Current Zoning: R-12MF(CD) (Multi-Family Residential, Conditional)

Proposed Zoning: R-12MF(CD) SPA (Multi-Family Residential, Conditional, Site Plan Amendment)

Approximately 42.85 acres located on the south side of Pineville-Matthews Road, east of Hugh Forest Road, and west of Reverdy Lane.

The petition proposes to redevelop 66 of the existing 266 multi-family dwelling units on the western portion of the site with 300 new units for a total of 500 dwelling units on the site located in southeast Charlotte.

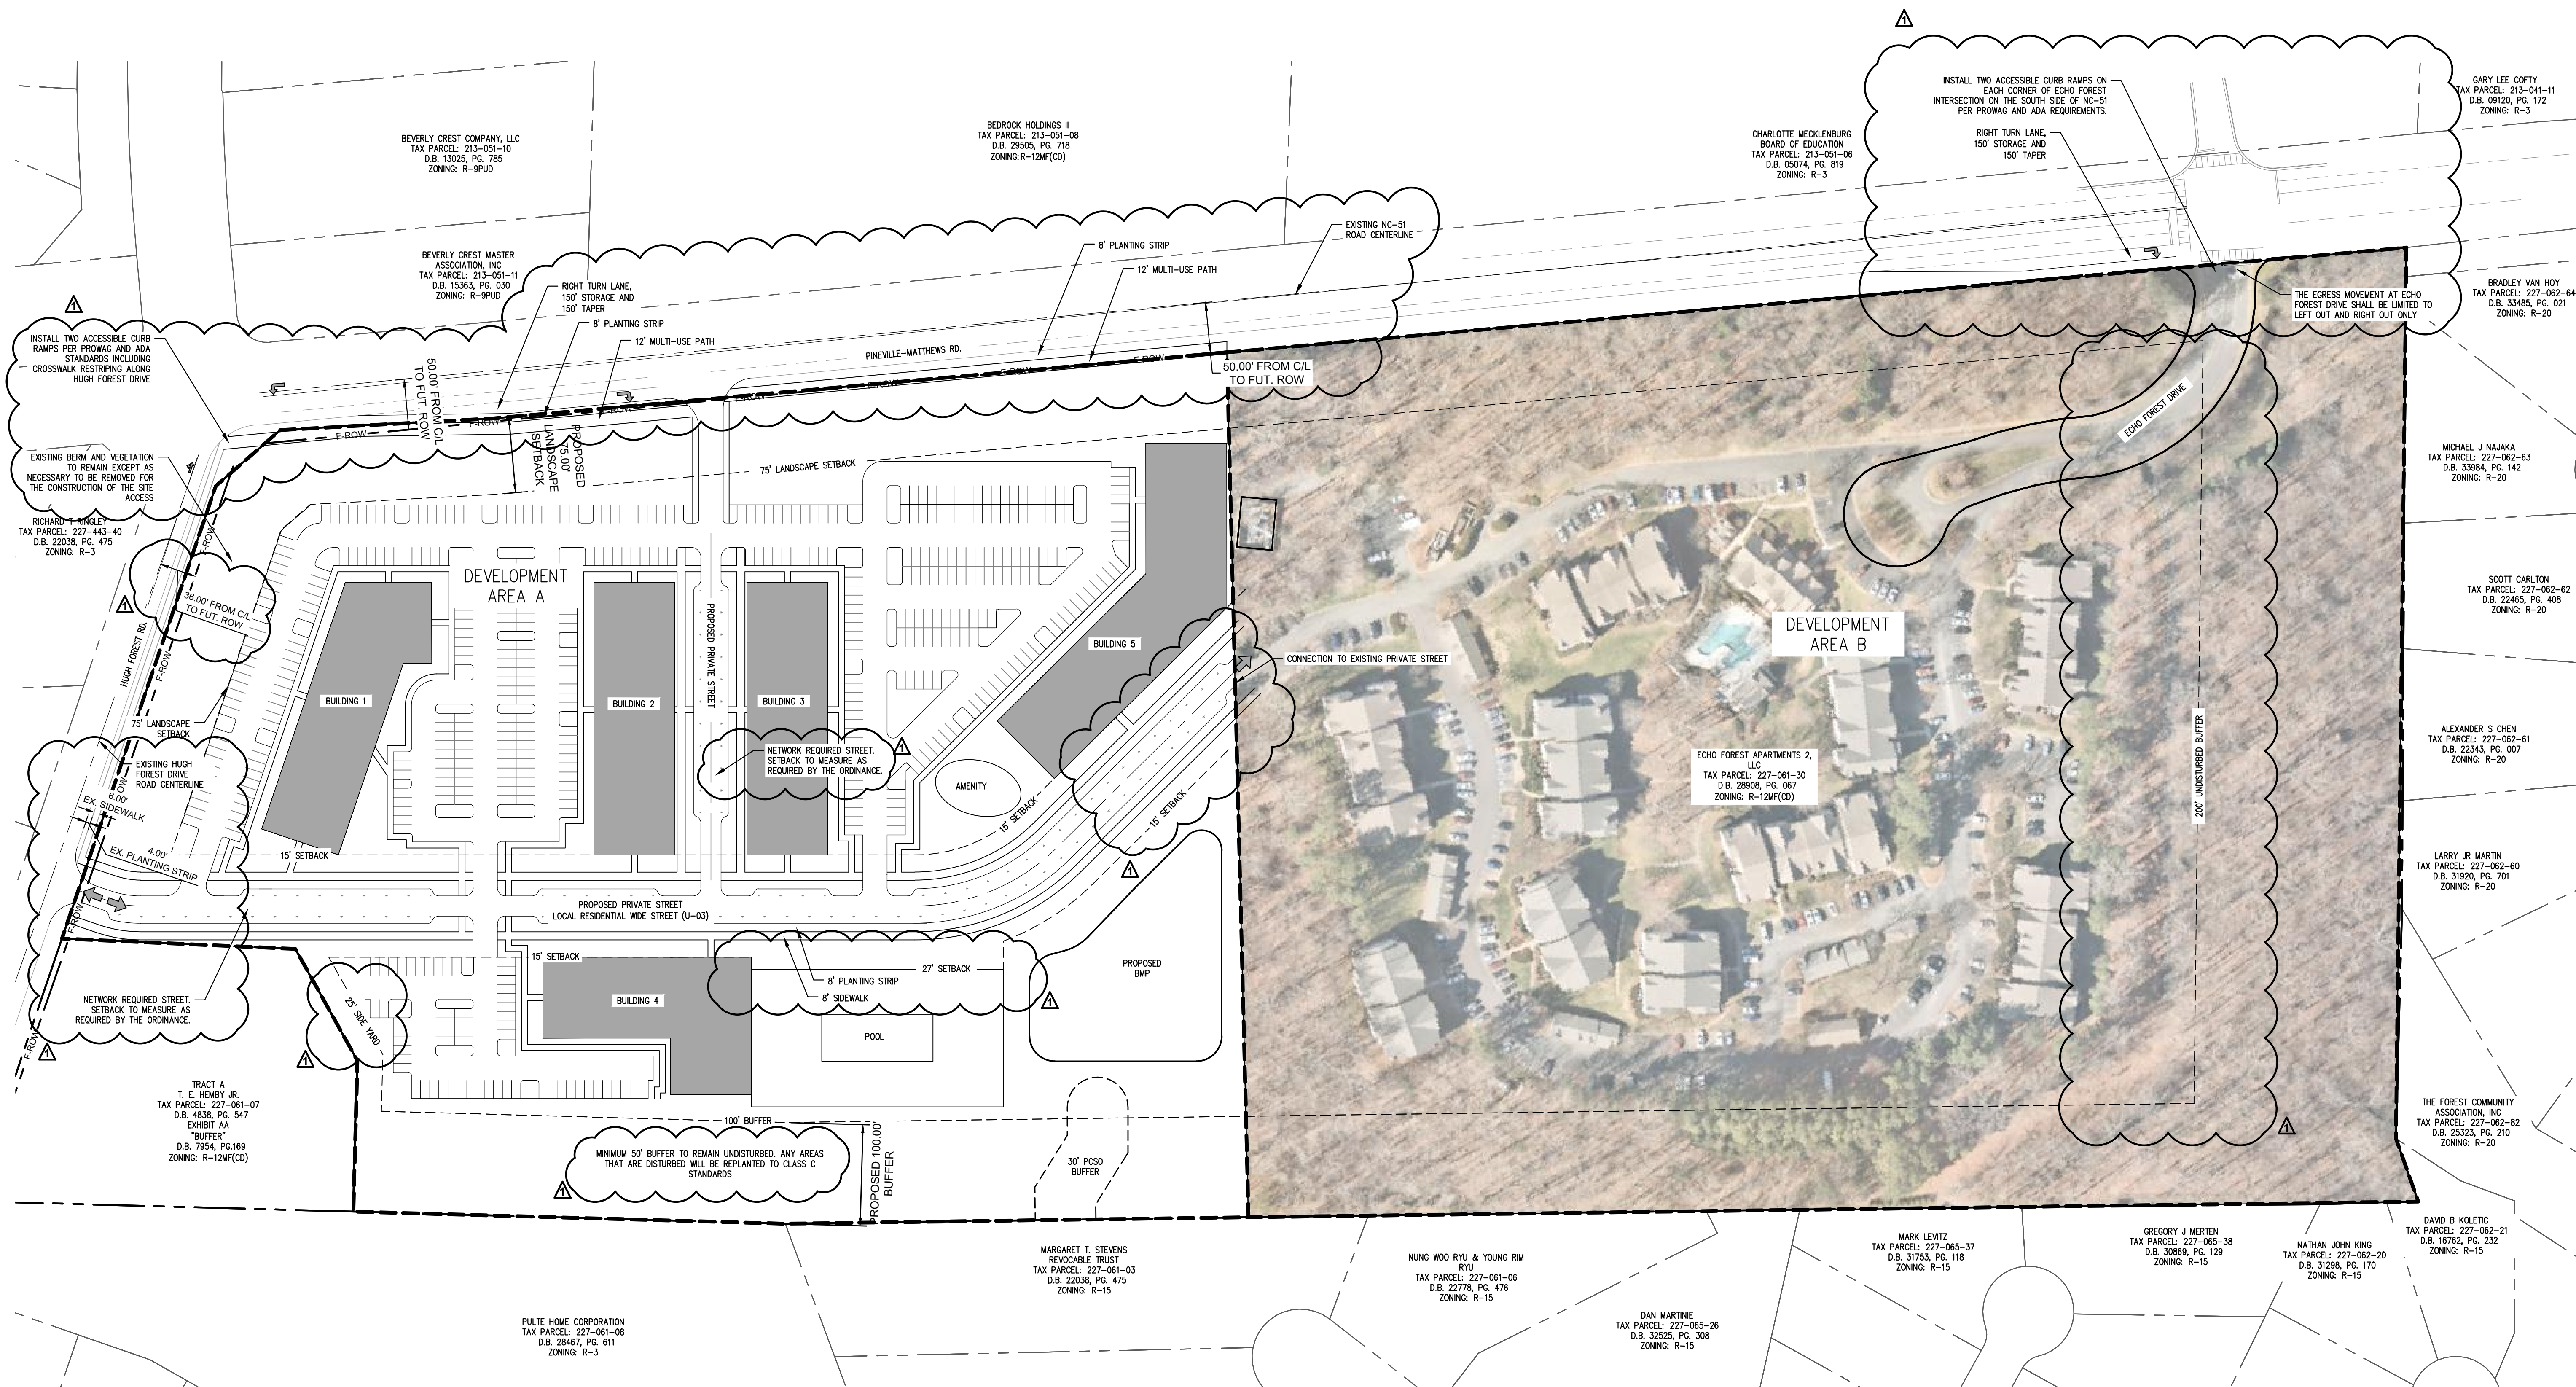
2. Amend the label on the site cross section from "existing road" to "Existing Hugh Forest Road"
3. Clarify proposed improved open space adjacent to MUP in note 6b is in addition to the minimum 10,000 square feet in noted 6a.
